**MP11\_0002 (MOD 1) (RESIDENTIAL BUILDINGS R8 & R9) - RESPONSE TO SUBMISSIONS  
BARANGAROO SOUTH**

We write to you on behalf of the proponent Lend Lease, in response to the issues raised in relation to Modification 1 to Residential Buildings R8 & R9 (MP11\_0002) (herein after referred to as Residential Buildings R8 & R9 (Mod 1)).

This response also includes an addendum relating to the following design amendments:

5 ELEVATION Lime Street Shopfront - Type E
1:50

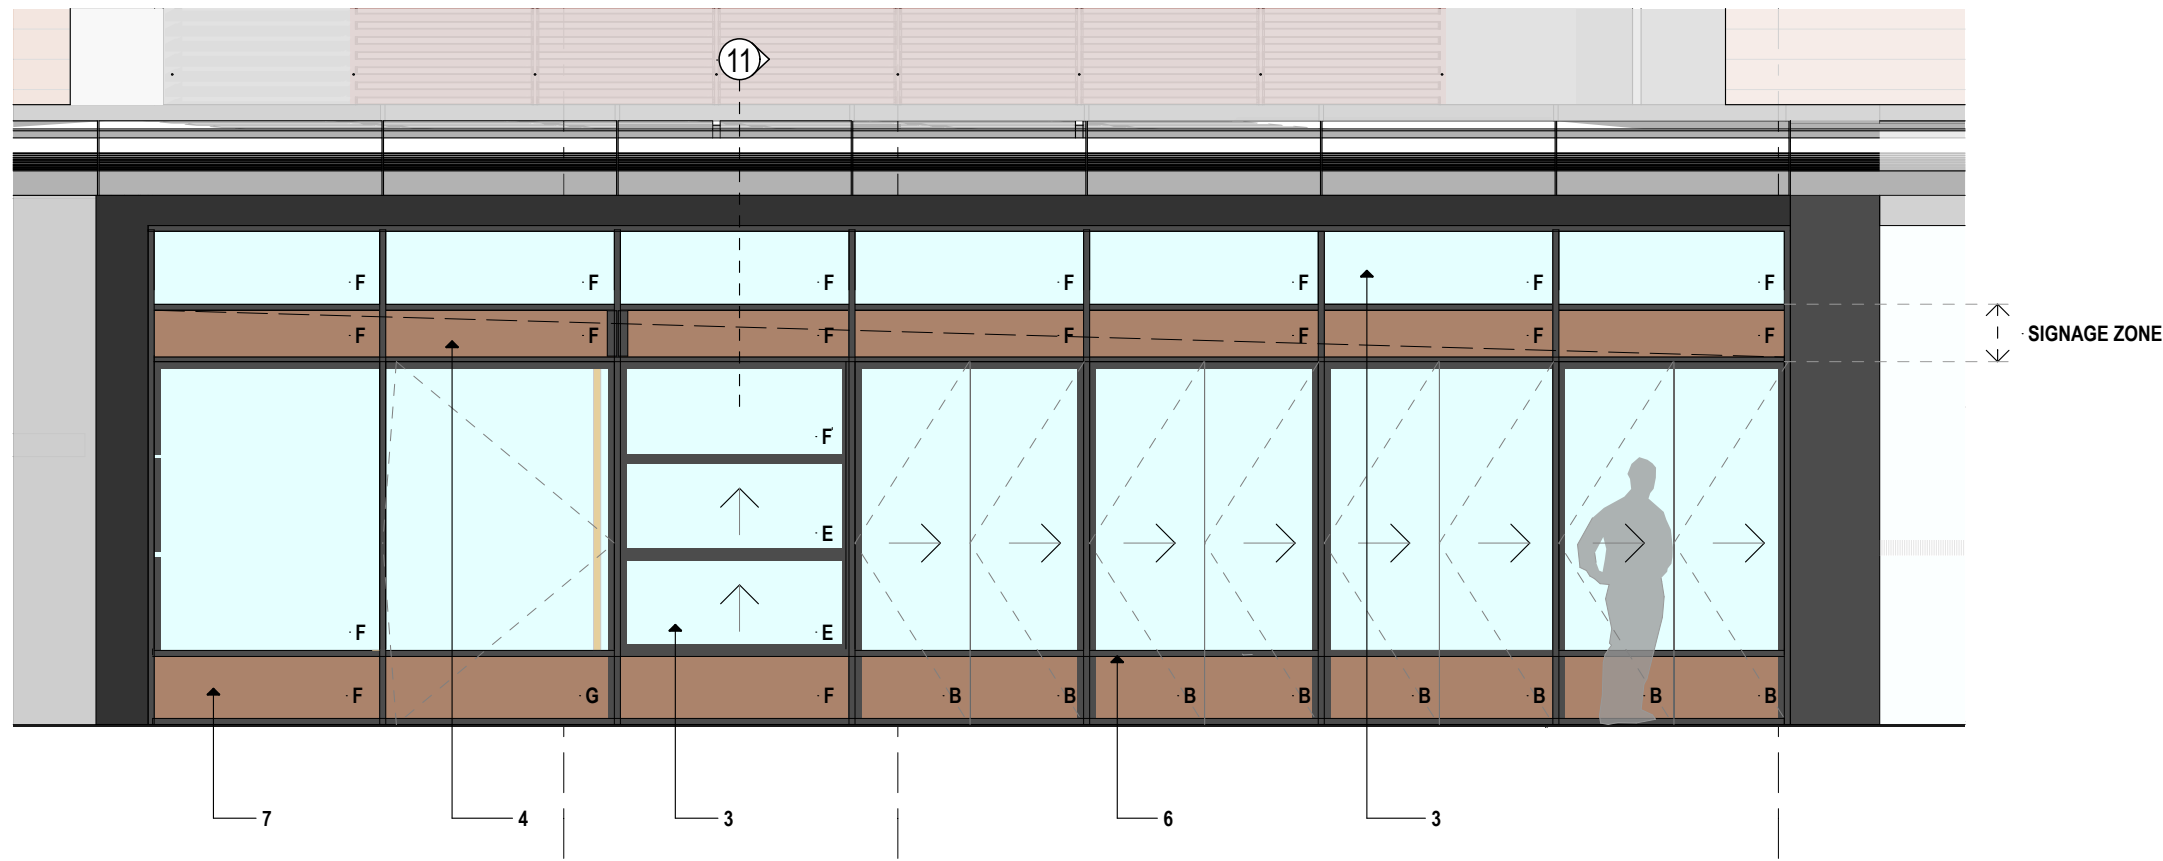
The proposed amendments to the shopfronts on the western, northern and southern façade of Buildings R8 & R9 are indicated on the Architectural Drawings with notations. These notations identify that the detailed design of the shopfronts will either be the subject of design development undertaken by Lend Lease, or the subject of a further approvals by the future tenants, prior to construction. The following design parameters have been included in these notations in order to provide guidance under both scenarios:

- minimum 55% transparency glazing for shopfronts; and
- partially operable shopfronts are permitted.

***Separate approvals are required for the detailed design of shopfronts. The future shopfront designs of Buildings R8 & R9 are to be consistent with the following:***

- ***All works must comply with the Building Code of Australia and relevant Australian Standards;***
- ***Shopfronts may include operable/fixed elements, such as glazing, windows, doors, benches and the like;***
- ***The minimum transparency of the glazing is to be 55%; and***
- ***Signage is to be consistent with the signage strategy, which is to be submitted to the Secretary prior to issue of a relevant construction certificate.***
